ENG-PUDSP21010-R3-CDs-Channel.pdf Markup Summary

Comments remain cursory due to the need for the design report, additional grading, complete details and how this ties in to the ultimate subdivision design.

Engineering Review
 04/20/2022 4:17:19 PM
 dsdrice
 JctRisks@engr.com
 (714) 933-7877
 EPC Planning & Community
 Development Department

GRANDVIEW METRO DISTRICT
 CHANNEL B GRADING

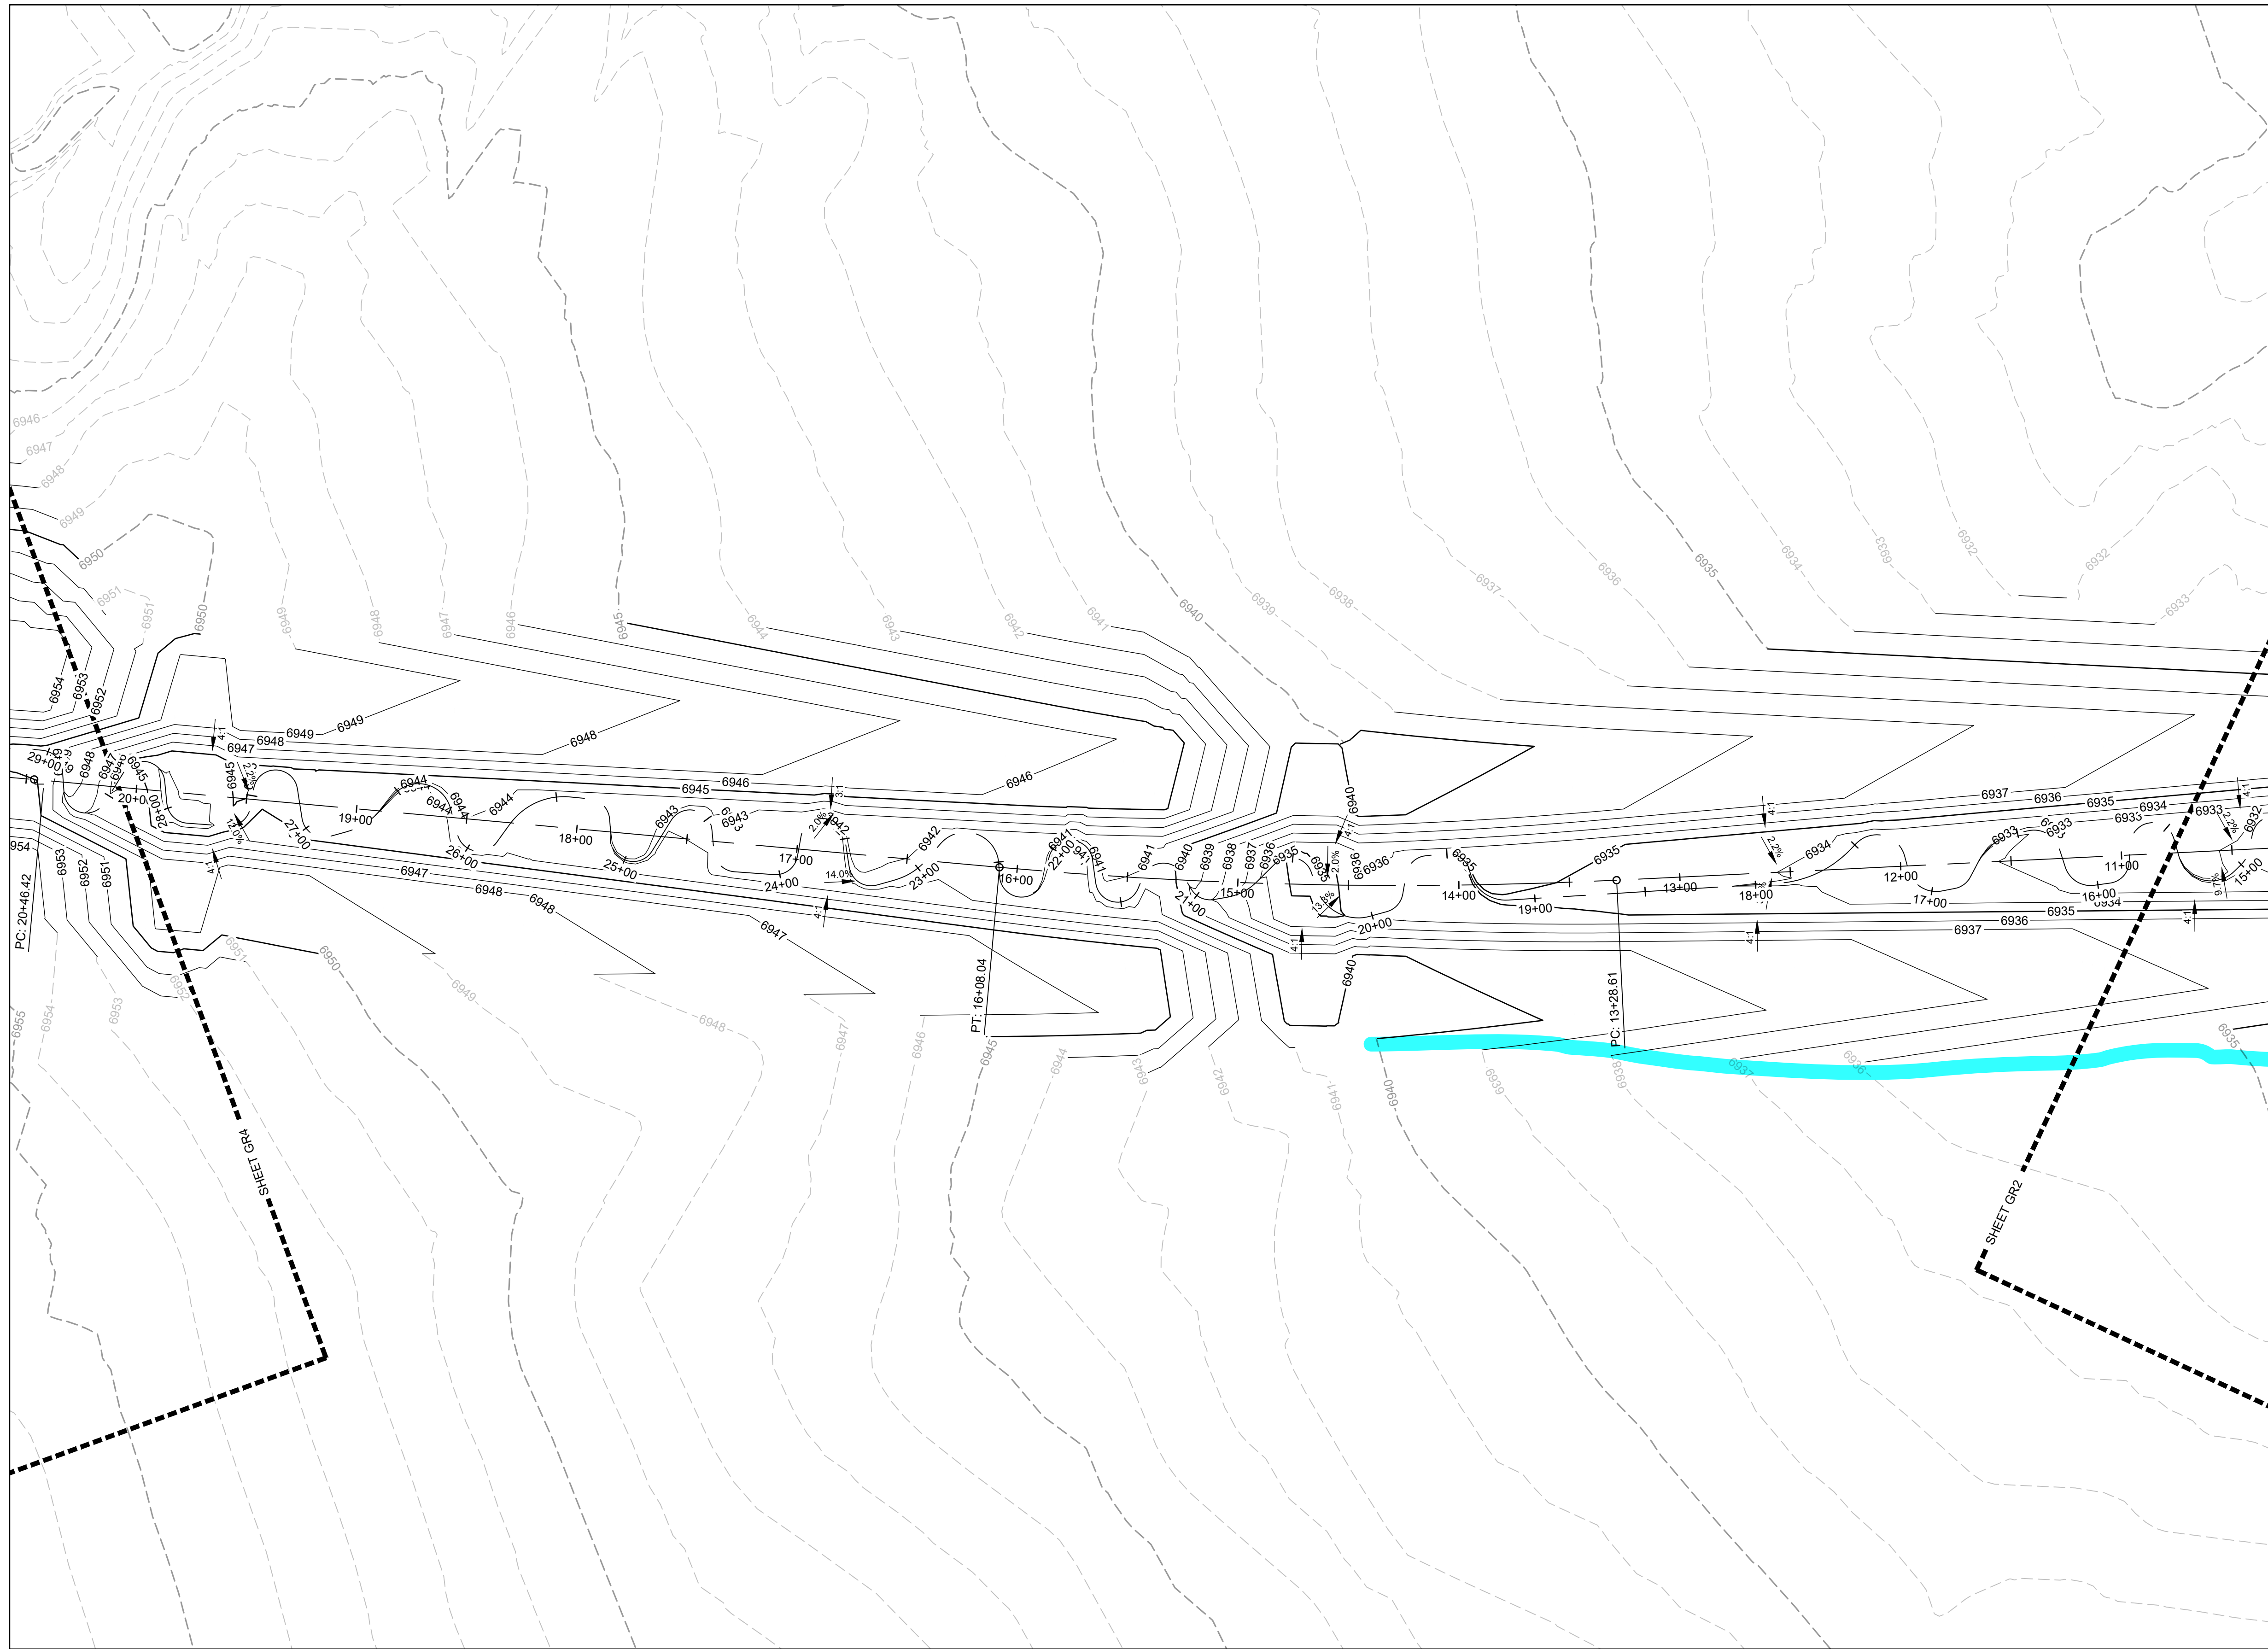
show all contours for proposed grading

Needs to be provided with the channel construction

contours don't match/contain the 100-year water surface

Show all necessary grading and stabilization improvements

Label the required easements

provide on both sides

SHEET NO.
GR3 06

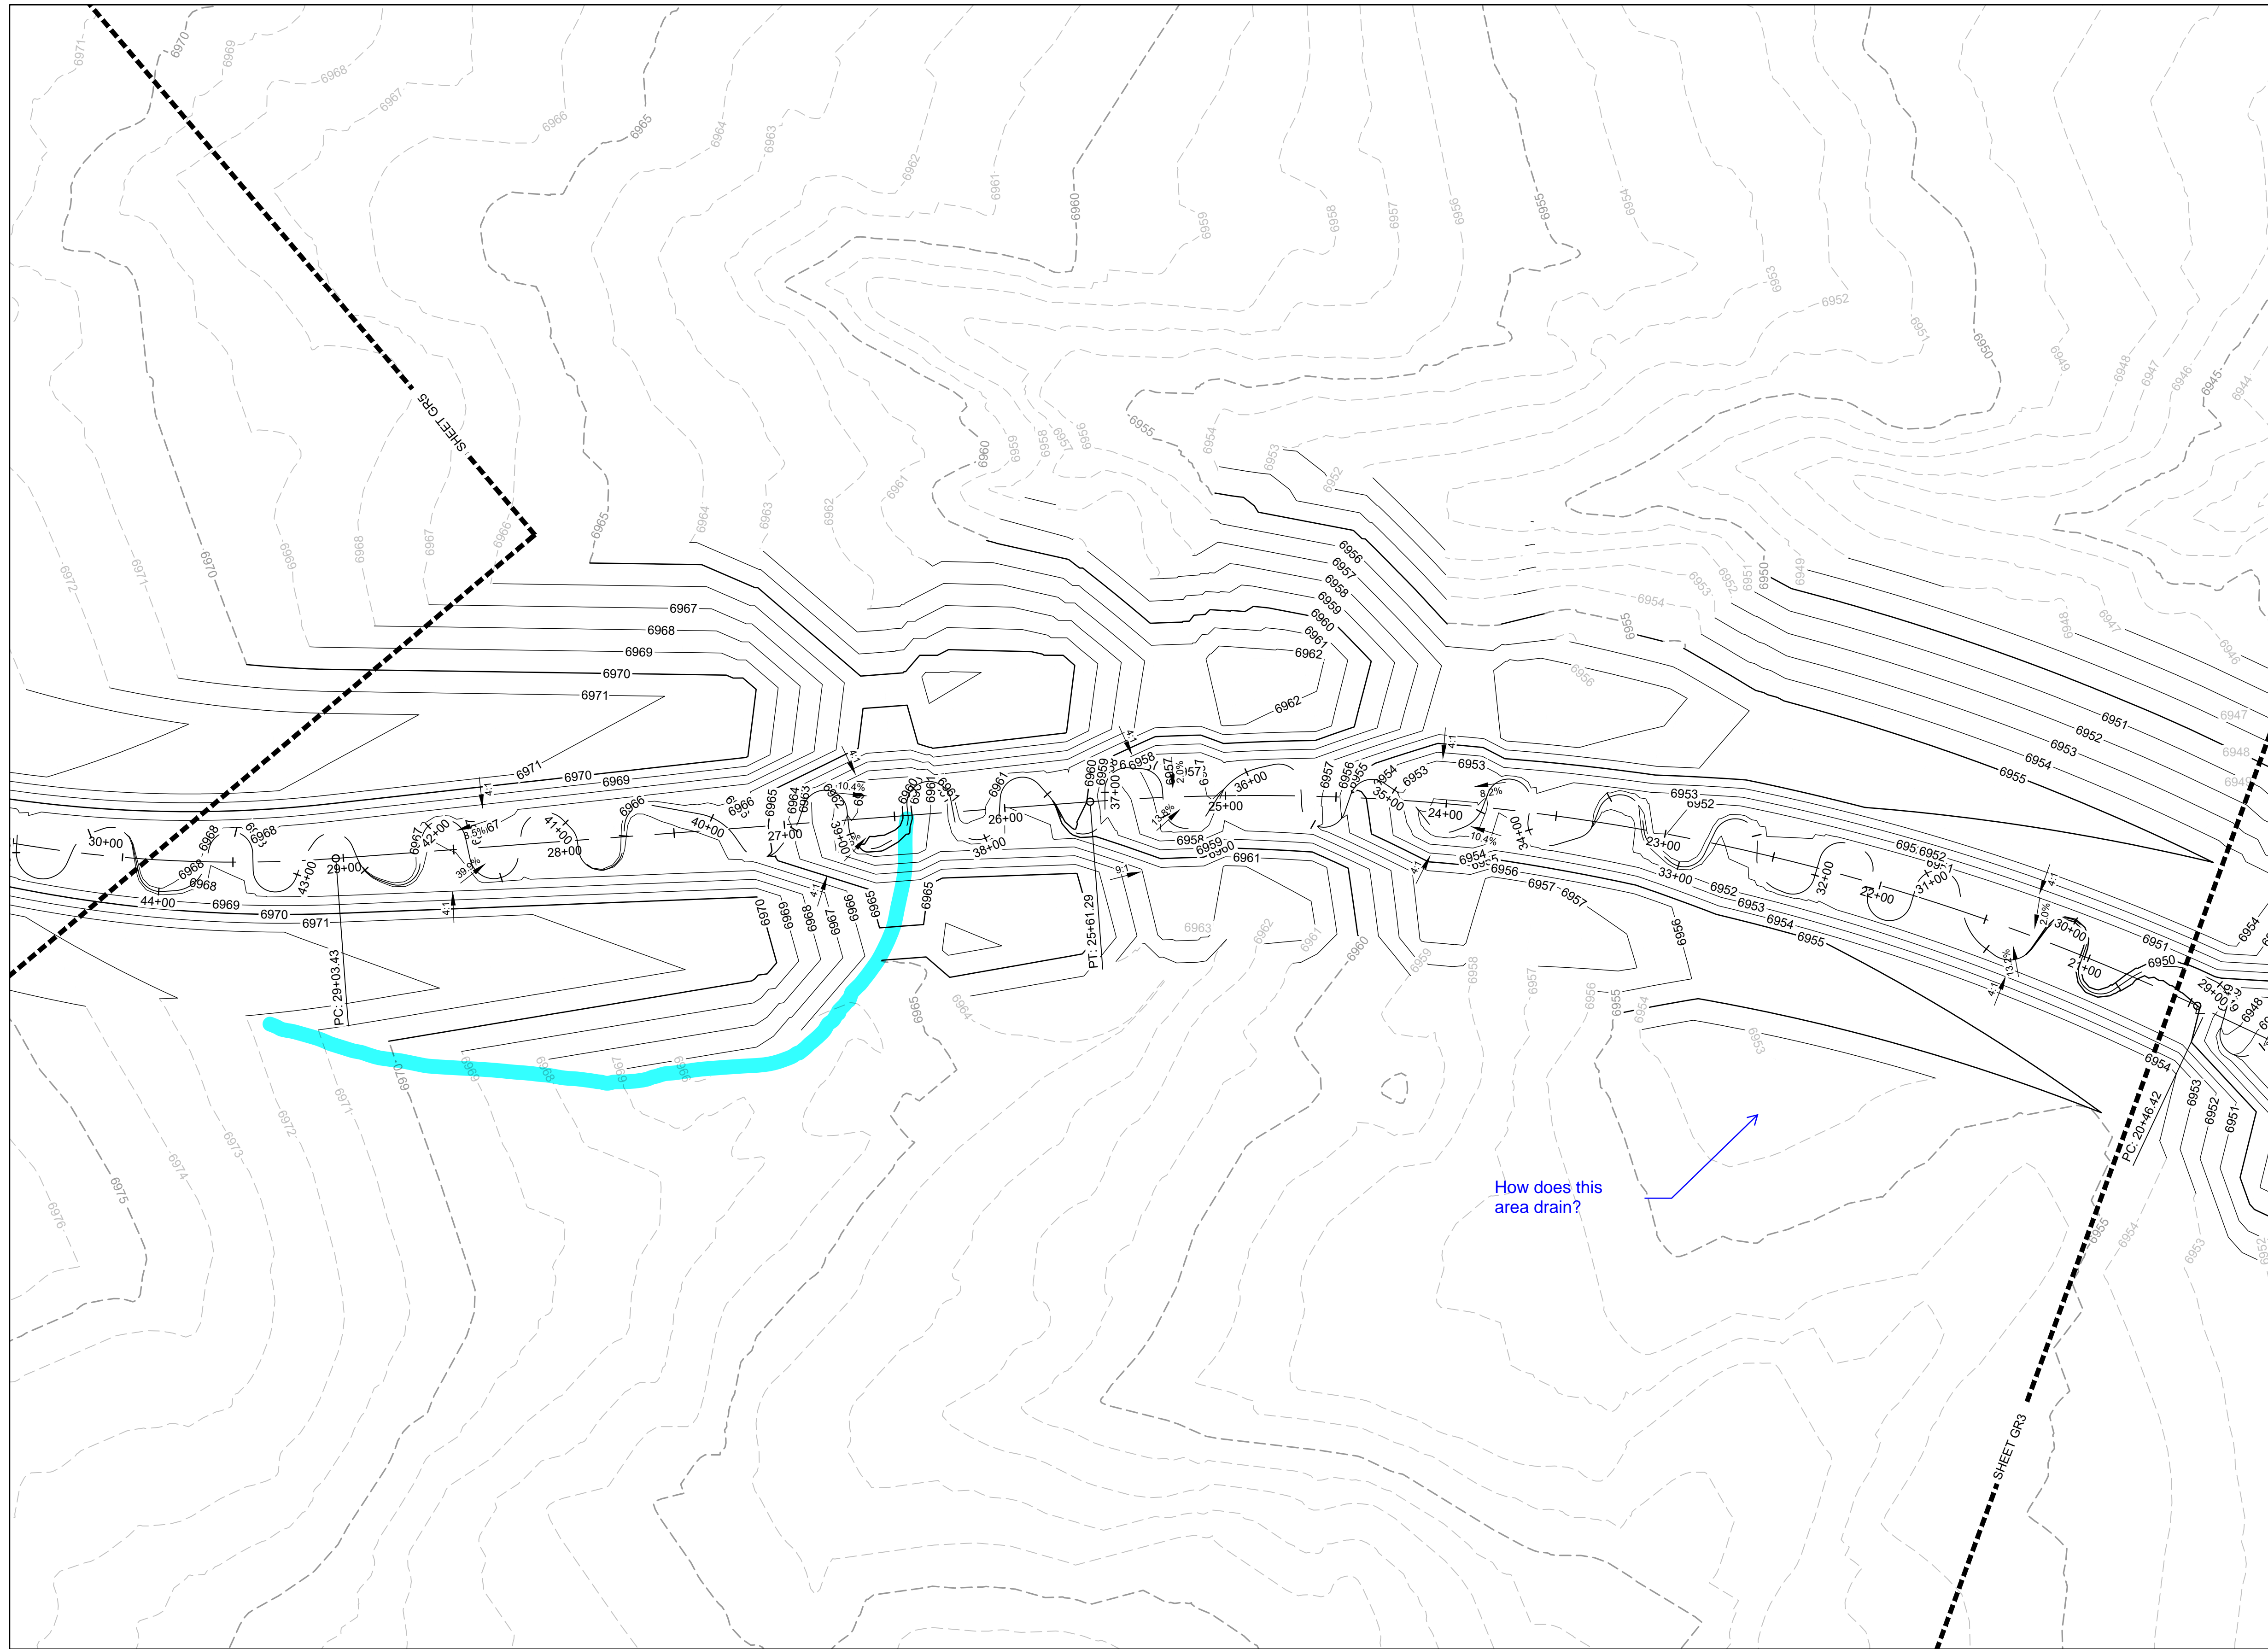
Delete

SHEET NO.
GR5 08

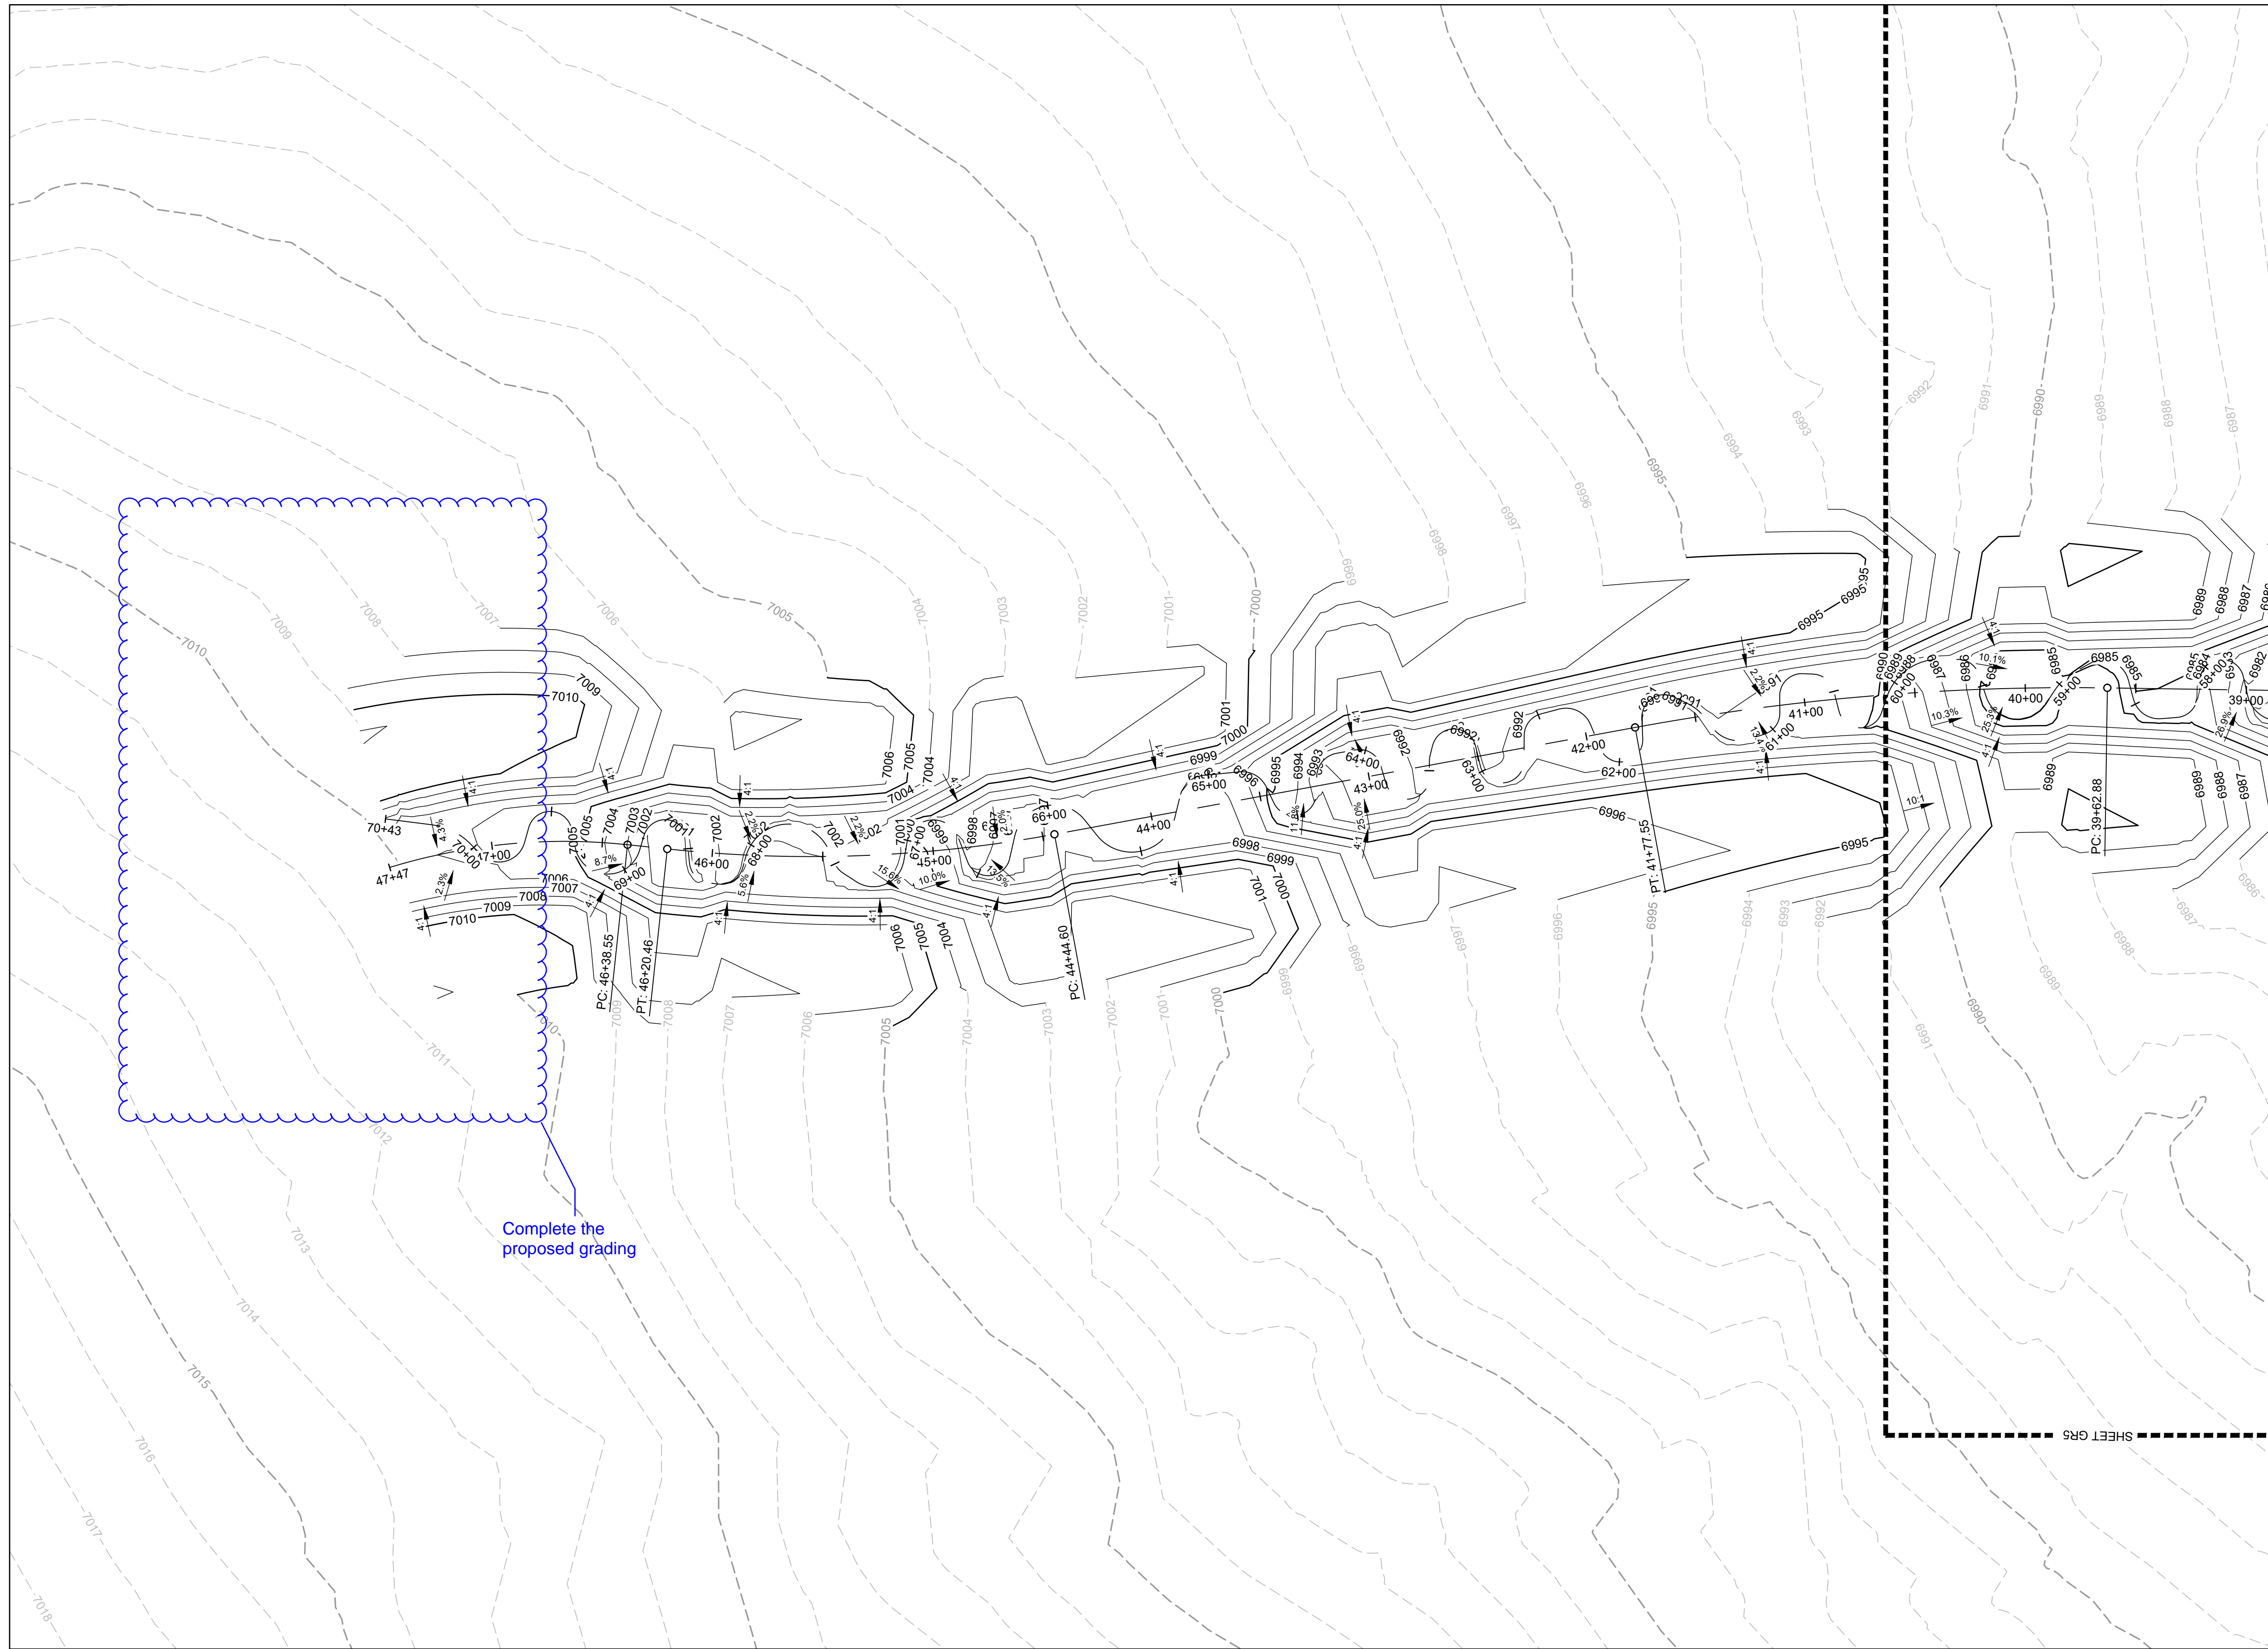
Show the culverts. Does the water surface take the culvert into account?
